# Rezoning Transportation Analysis

Petition Number: 2019-174

**From:** Felix Obregon, PE  
[fobregon@charlottenc.gov](mailto:fobregon@charlottenc.gov)  
704-432-5729

Date	Description
01-14-2020	First Review-MTH
02-17-2020	Second Review

ILLUSTRATIVE PLAN & NOTES

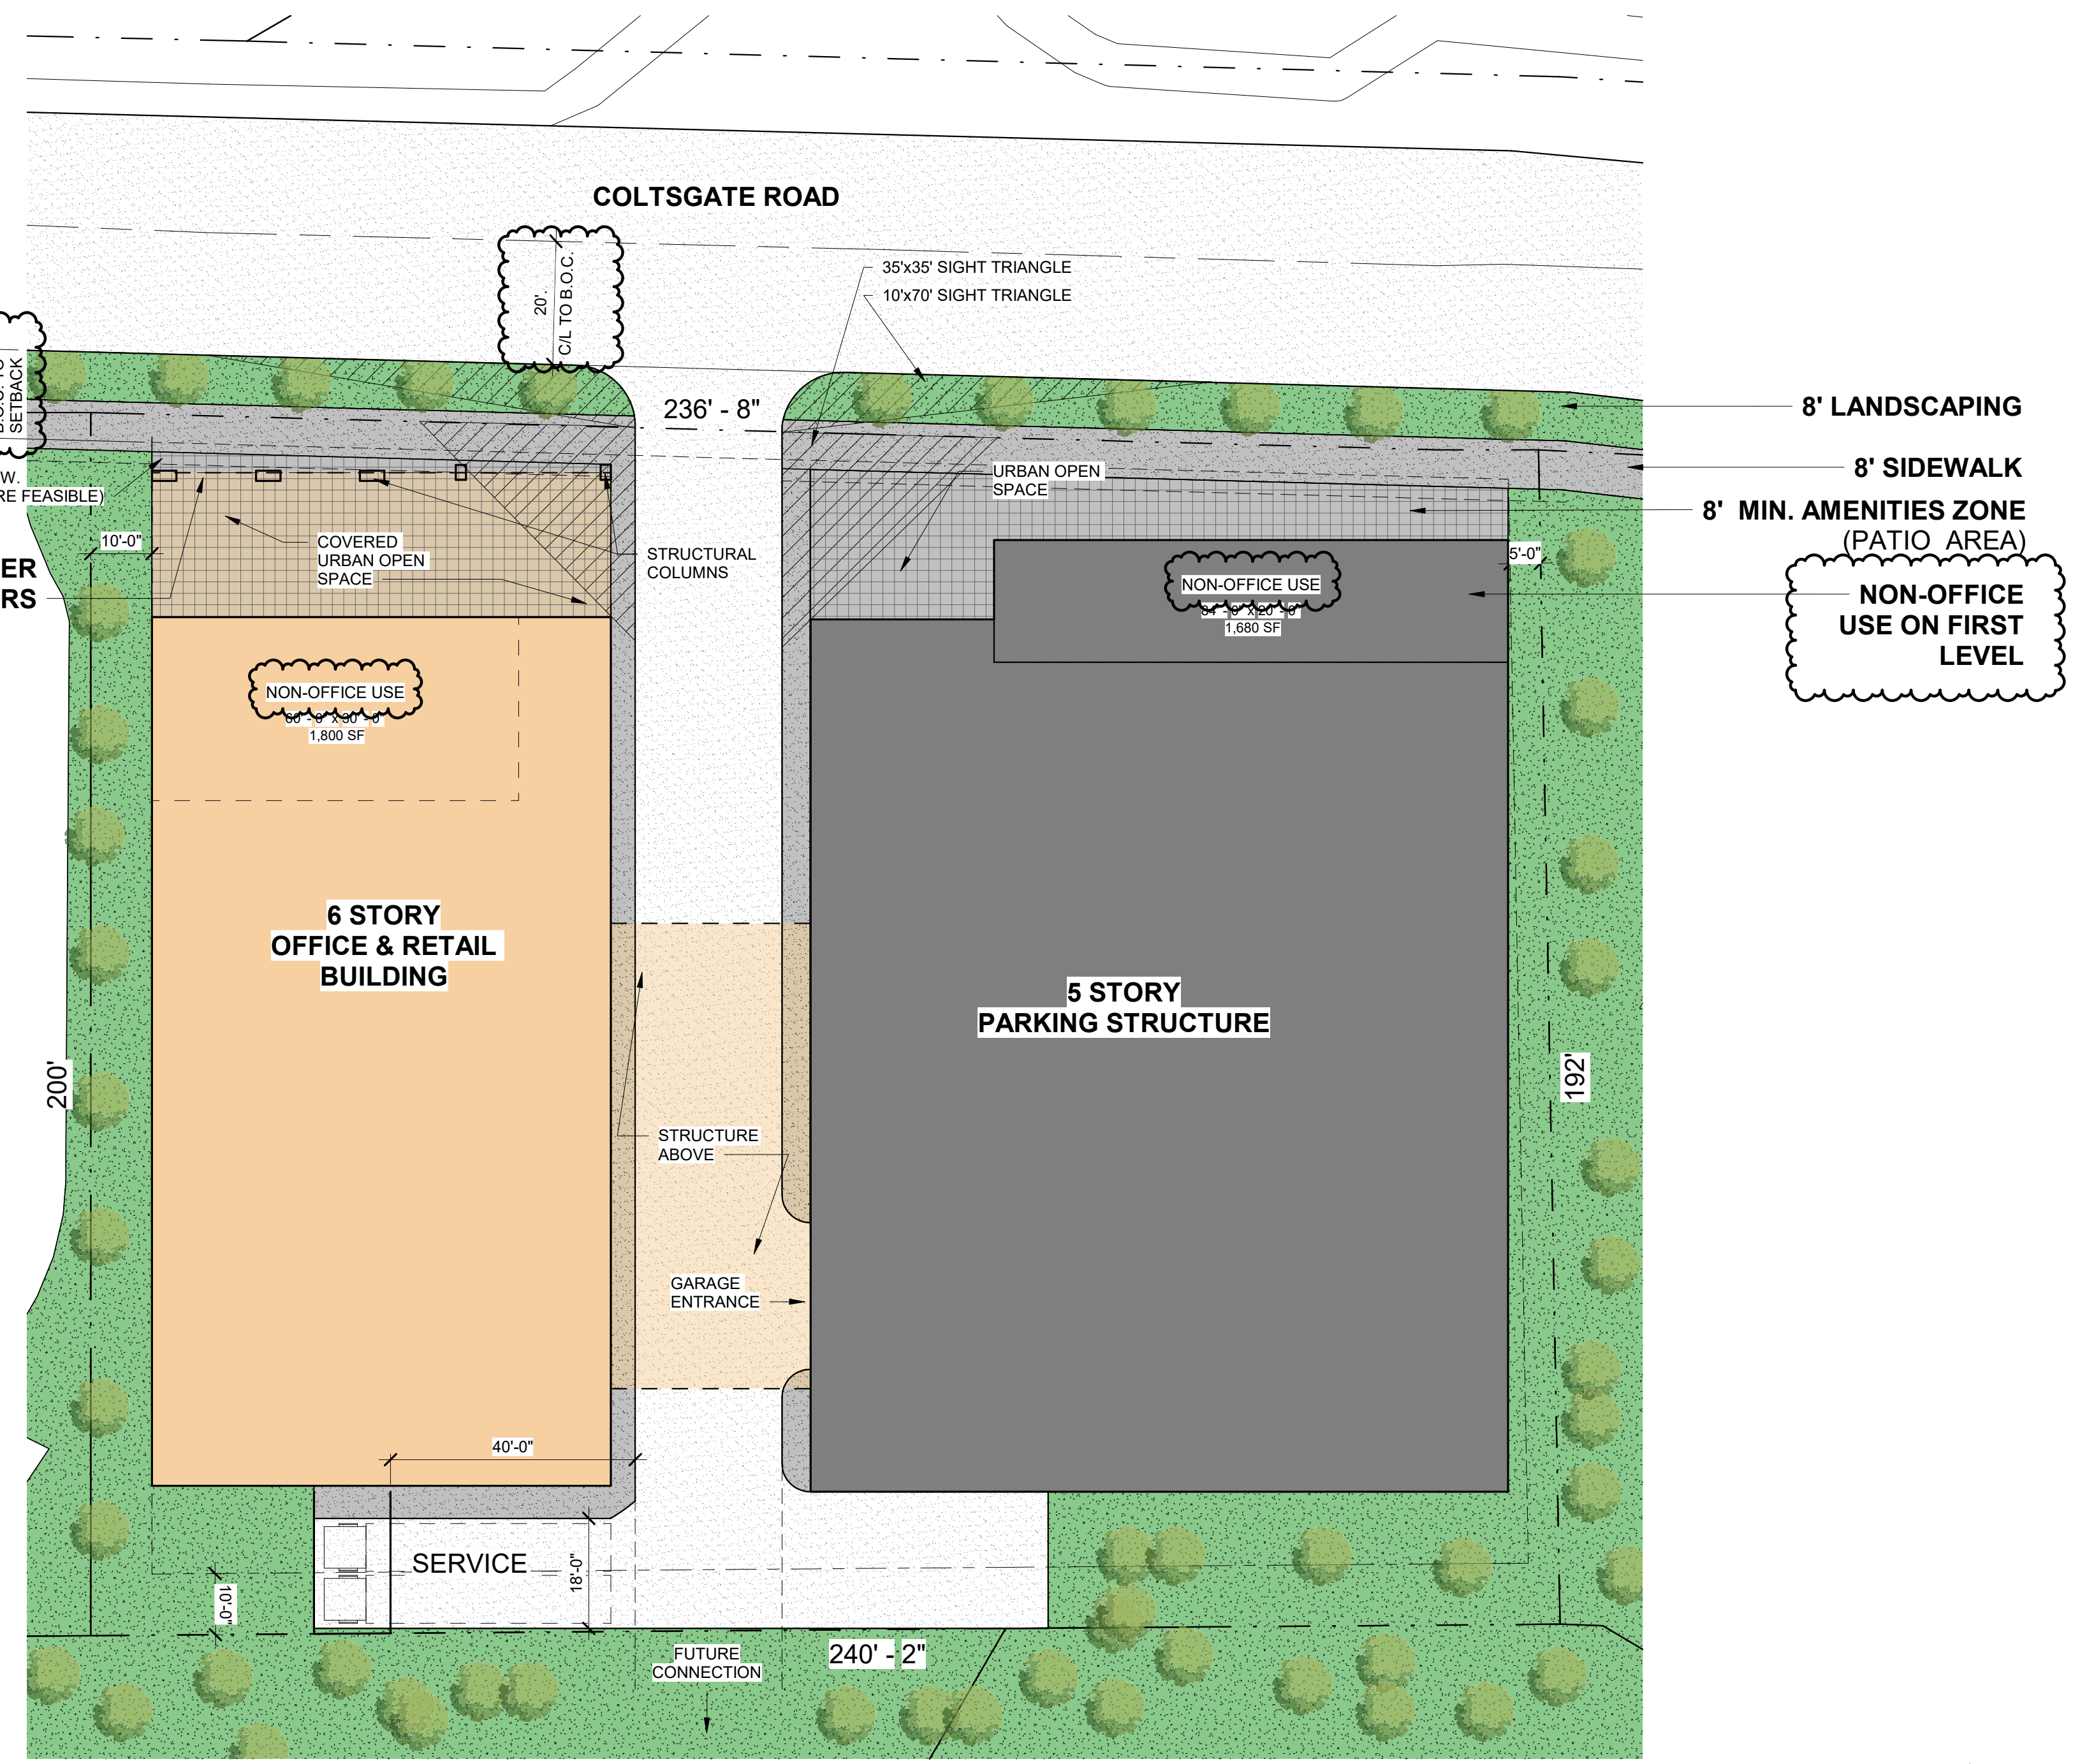
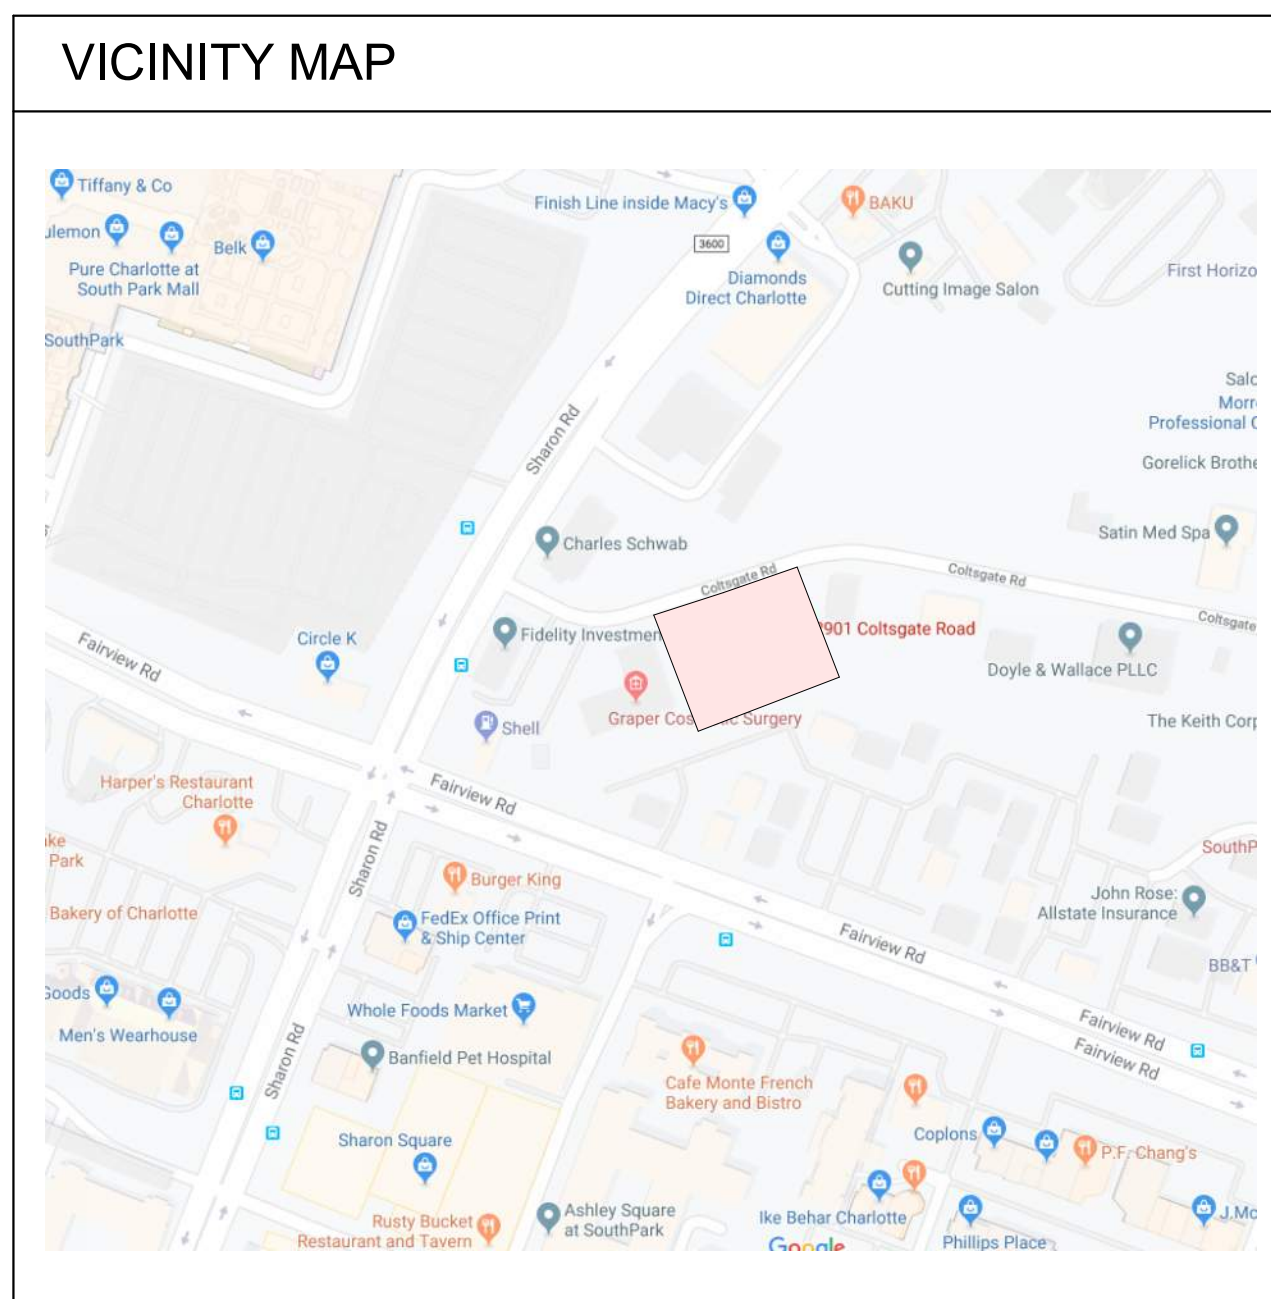
The site plan should show the curb and gutter labeled and dimensioned from the centerline for each road.

**Technical Correction based on site plan 02/10/2020:** Petitioner is showing dimension from C/L to what appears to be edge of pavement, please updated to dimension existing back of curb.
